CBD AND SOUTH EAST LIGHT RAIL (CSELR)
EIS NOISE & VIBRATION ASSESSEMENT
INDEPENDENT ADEQUACY REVIEW & GAP ANALYSIS

REPORT NO. 14055
VERSION A

APRIL 2014

DEPARTMENT OF PLANNING
& INFRASTRUCTURE (DP&I)
BRIDGE STREET
SYDNEY NSW 2000

Figure 15.20 Plots of predicted residential operational airborne noise for the 2036 future scenario (without mitigation)

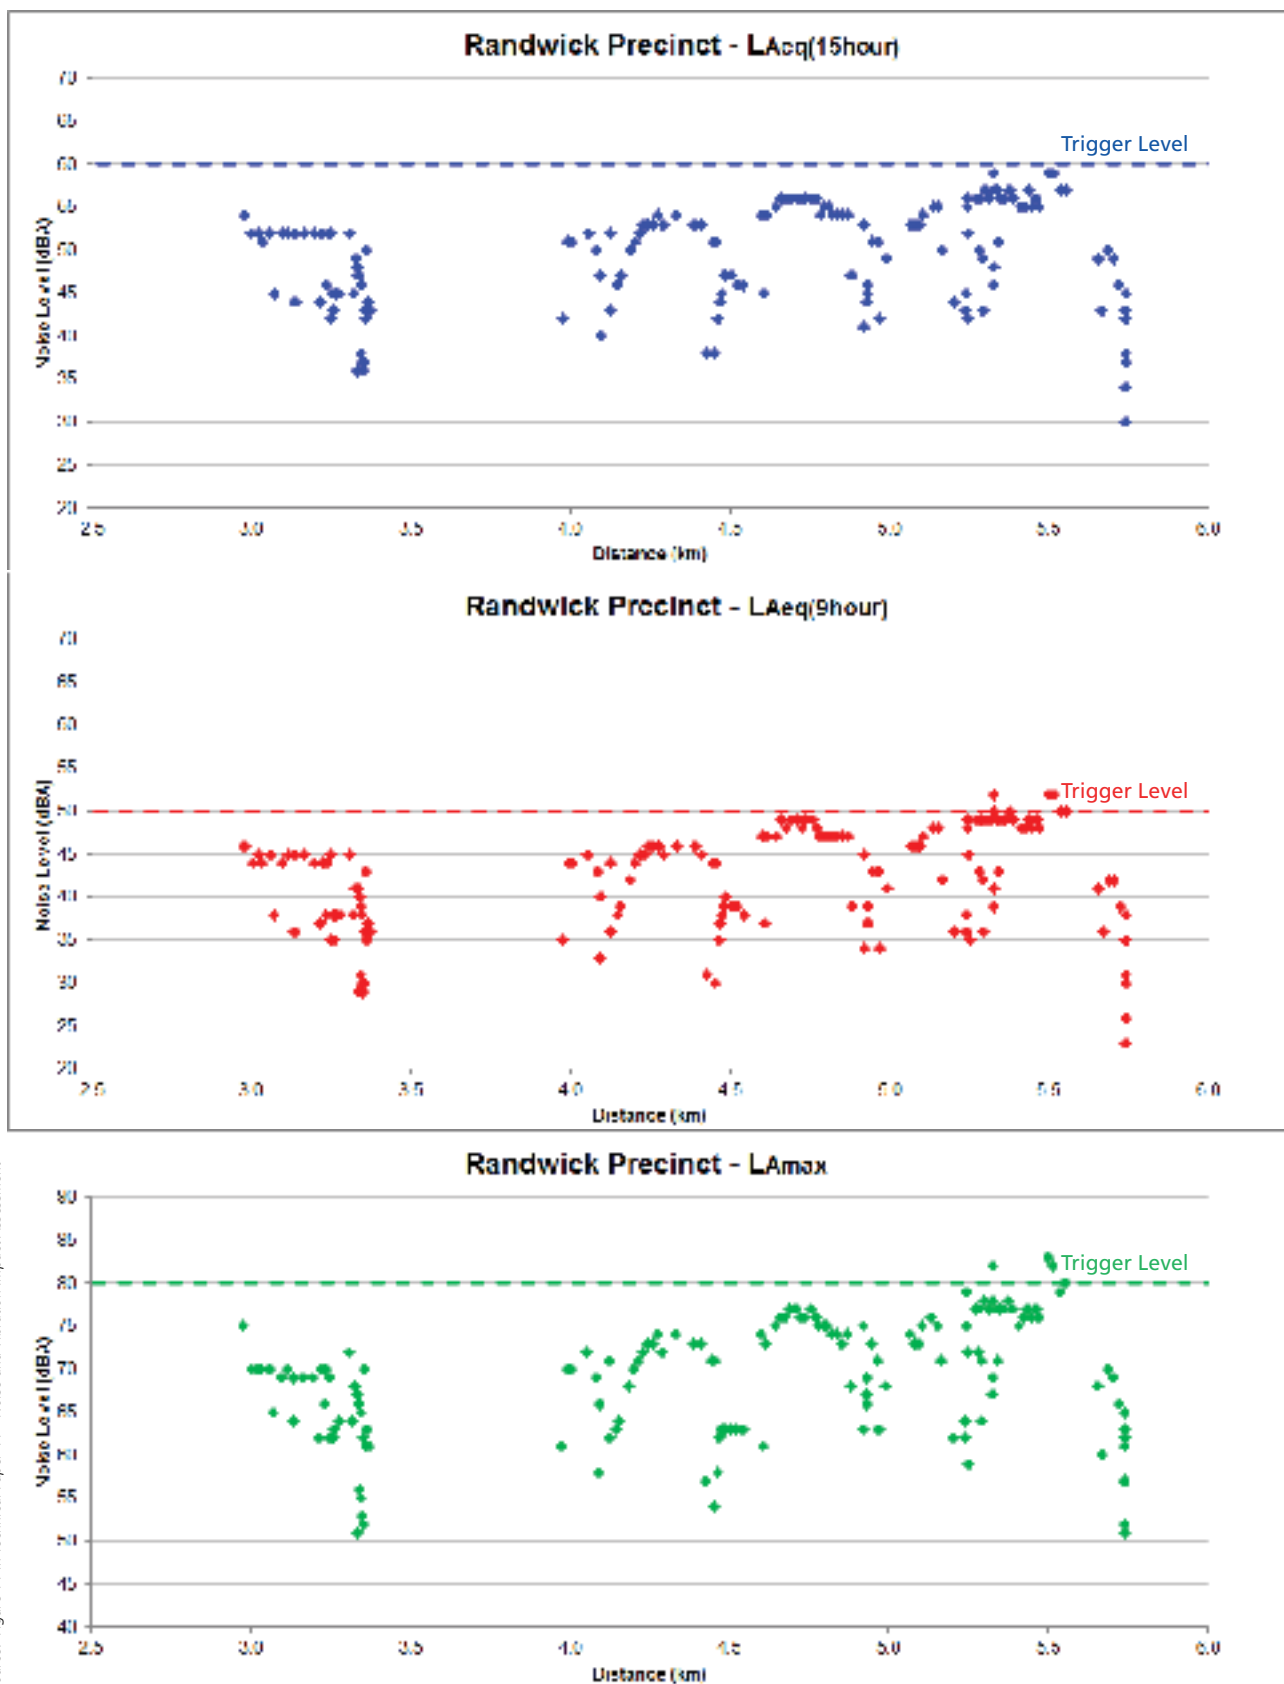
The other main area of concern is Randwick where High Street has three apartment buildings with 2 dB exceedance of the $L_{Aeq,9hr}$ trigger.

Figure 13.18 Plots of predicted Surry Hills Precinct residential operational airborne noise for the 2036 future scenario (without mitigation)

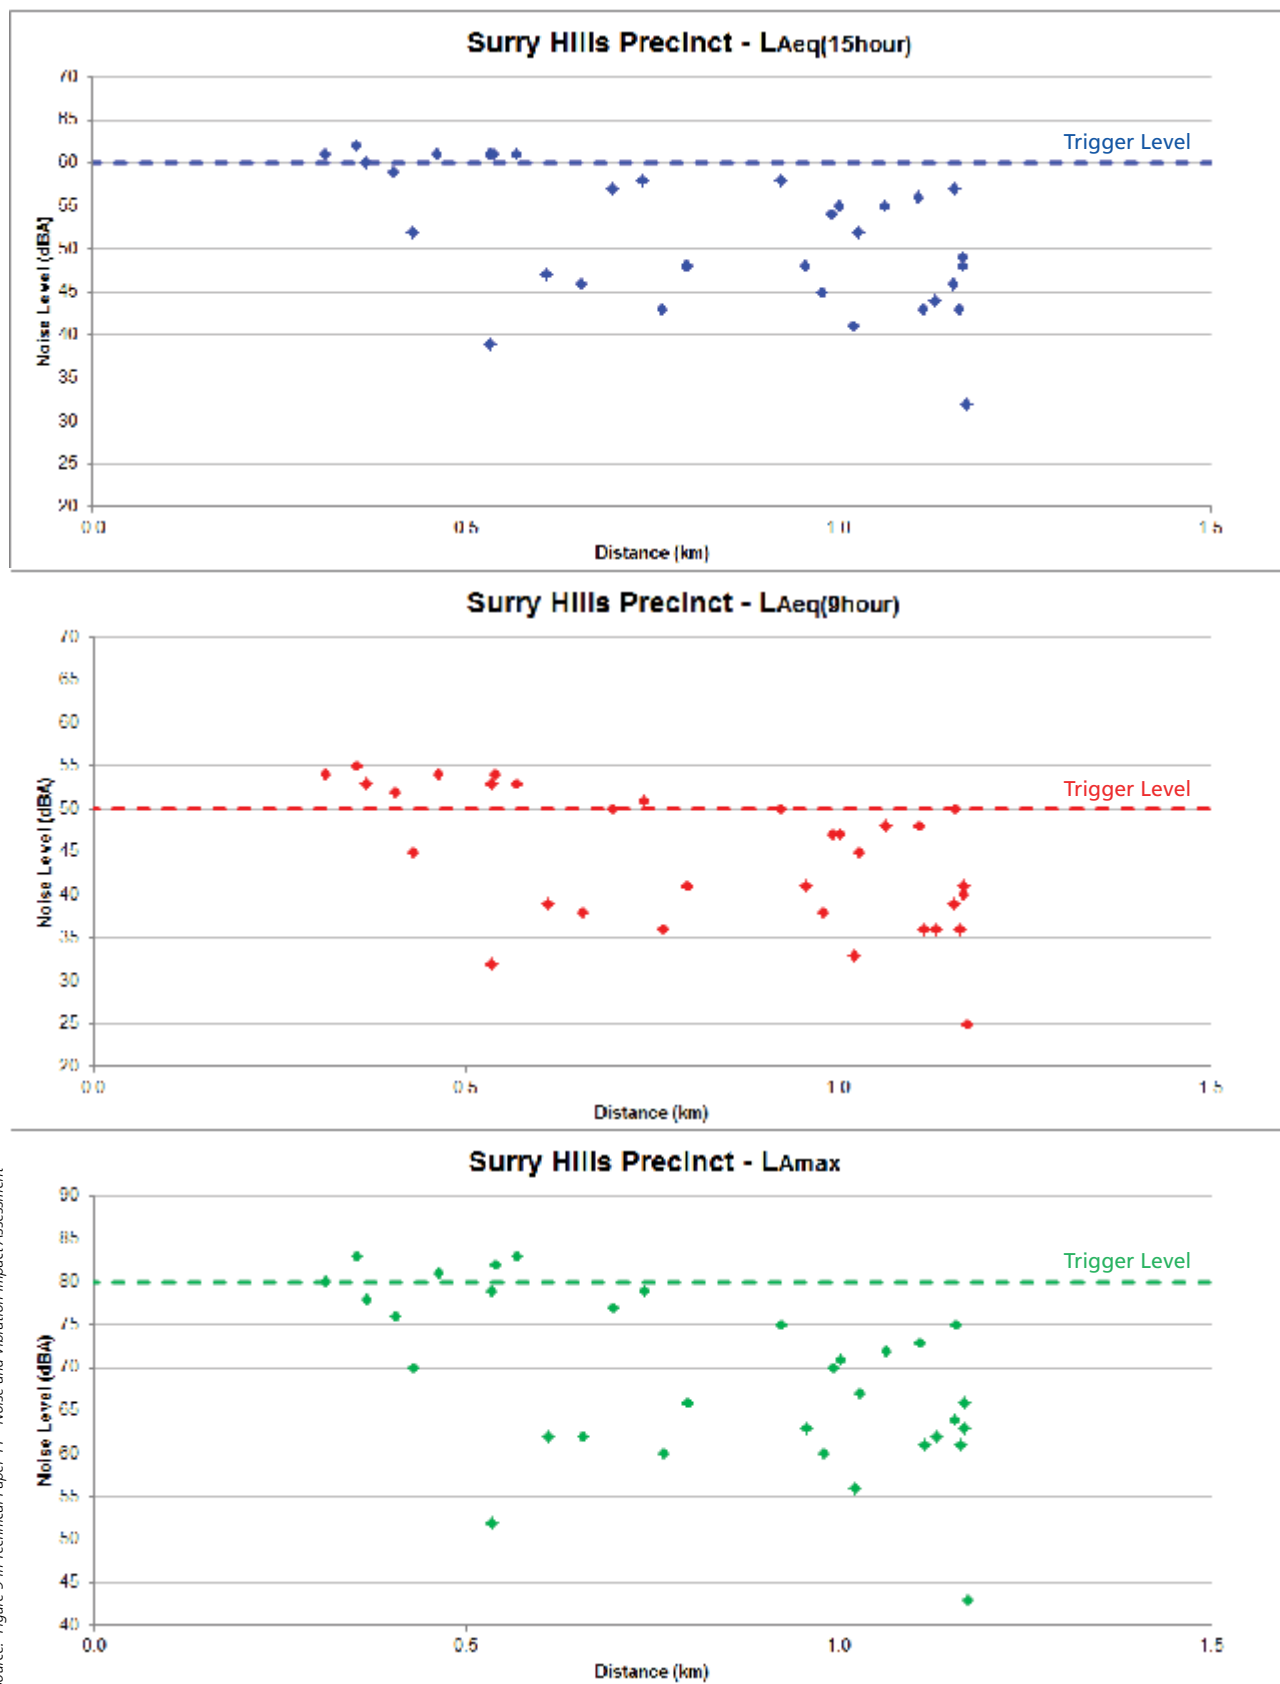
As shown in Table 3-2, the greatest potential impacts appear to be within the Surry Hills Precinct. In this area, the daytime $L_{Aeq,15hr}$ trigger level is predicted to be exceeded by up to 2 dB and the night time $L_{Aeq,9hr}$ trigger level is predicted to be exceeded by up to 5 dB. Additionally the L_{Amax} trigger level is predicted to be exceeded by up to 3 dB.

The EIS NVIA suggests that apart from on Devonshire Street, Surry Hills, the trigger level exceedances are predicted only in areas with relatively high existing road traffic noise and therefore in these areas it is unlikely there would be a noise impact.

- *In Surry Hills, consideration of reasonable and feasible mitigation of light rail noise is required at all locations where the RING trigger levels are exceeded.*
